Our ref: WA/2017/123424/03-L01
Your ref: 16/00205/DISC
Date: 05 April 2017

Discharge of condition 25 (verification report) of 10/01642/OUT

Heyford Park, Camp Road, Upper Heyford

Attached:  
Drawing D01

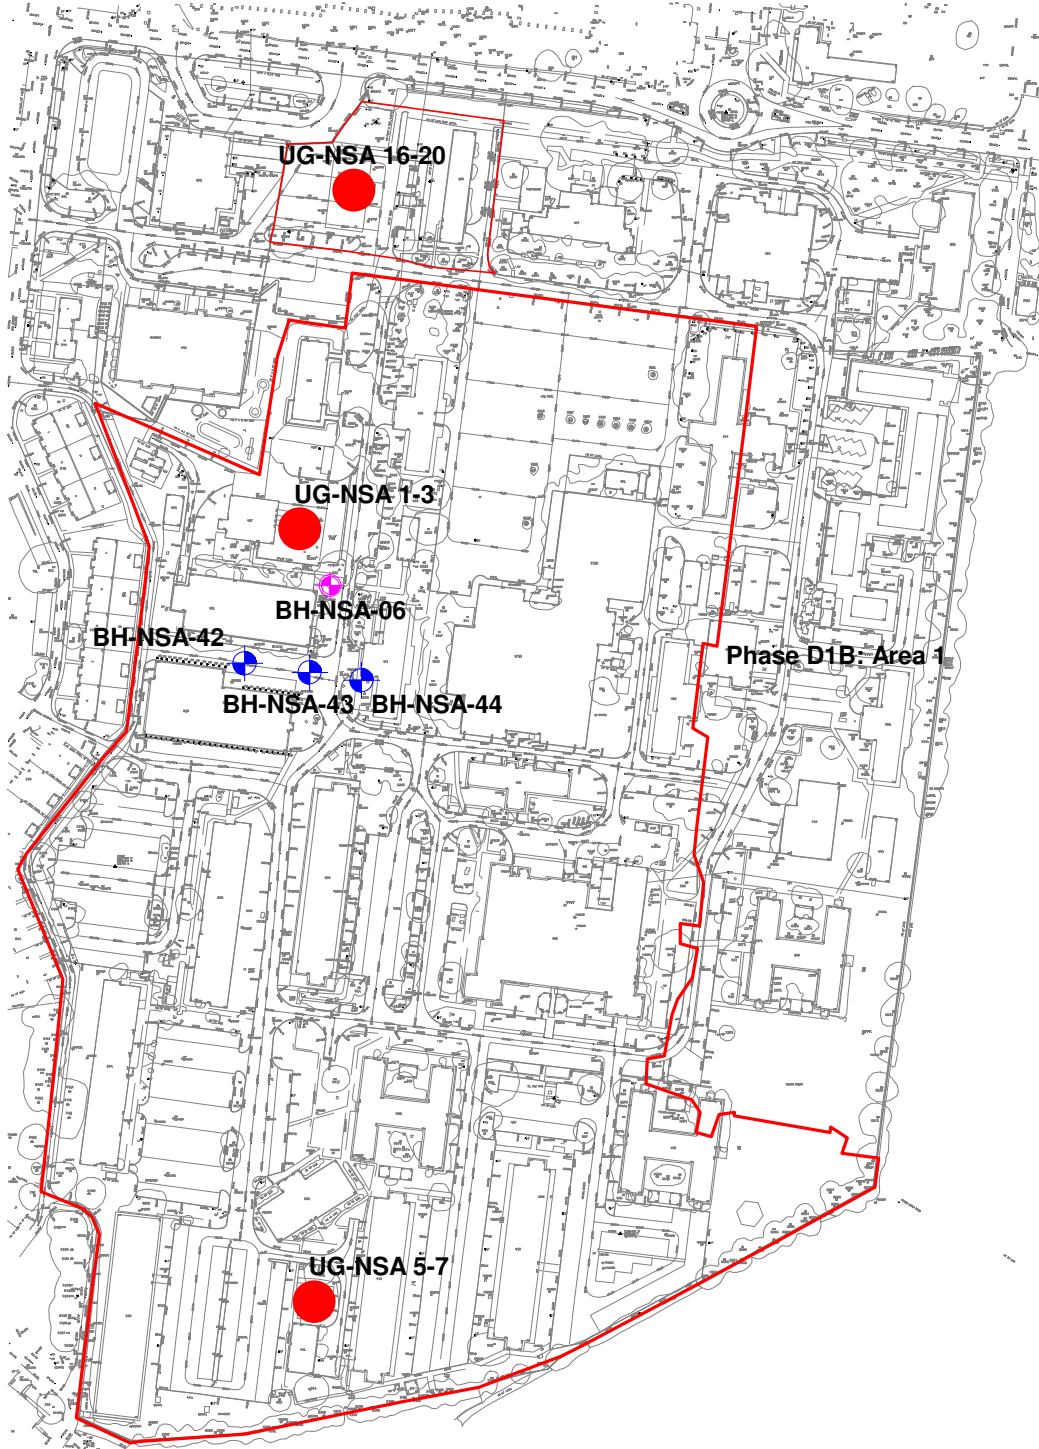
We have reviewed the letter from Smith Grant Environmental Consultancy dated 08 March 2017 and drawing no. L070317-D01.

There are a number of inconsistencies within the details we have reviewed and we are currently unable to confirm that the required level of remediation has been carried out. We are therefore unable at present to recommend that this condition can be discharged.

Whilst we agree that migration of contamination was not taking place (Section 7.3.1 of the Preliminary Ground Investigation Report, May 2012) there is other evidence in the same report that contradicts this statement.

We have seen evidence of hydrocarbon contamination being observed within borehole BH-NSA 43, in the form of sand with a faint hydrocarbon odour. This odour is recorded on the Rotary Borehole record and groundwater was struck at 3.1 m below ground level in a 10 m deep borehole. Borehole BH-NSA 43 is down hydraulic gradient of BH-NSA 06 where free phase LNAPL was encountered (Jomas Factual Report on Ground Investigation at Residual New Settlement Area, Upper Heyford dated April 2012 item 4.7.1. Appendix C of Waterman May 2012 Preliminary Generic Quantitative Environmental Risk Assessment - Preliminary Ground Investigation for the New Settlement Area).

The May 2012 report (item 9.5.3) indicates there is an exceedance of TPH at BH-NSA-43 and the analytical data on page 808 and 1029 provides the evidence of migration of contaminants and even a small concentration is also seen in BH-NSA 42. Results also suggest that the fuel at BH-NSA-43 was not entirely a weathered heavy fuel as considered to be present at BH-NSA-06.
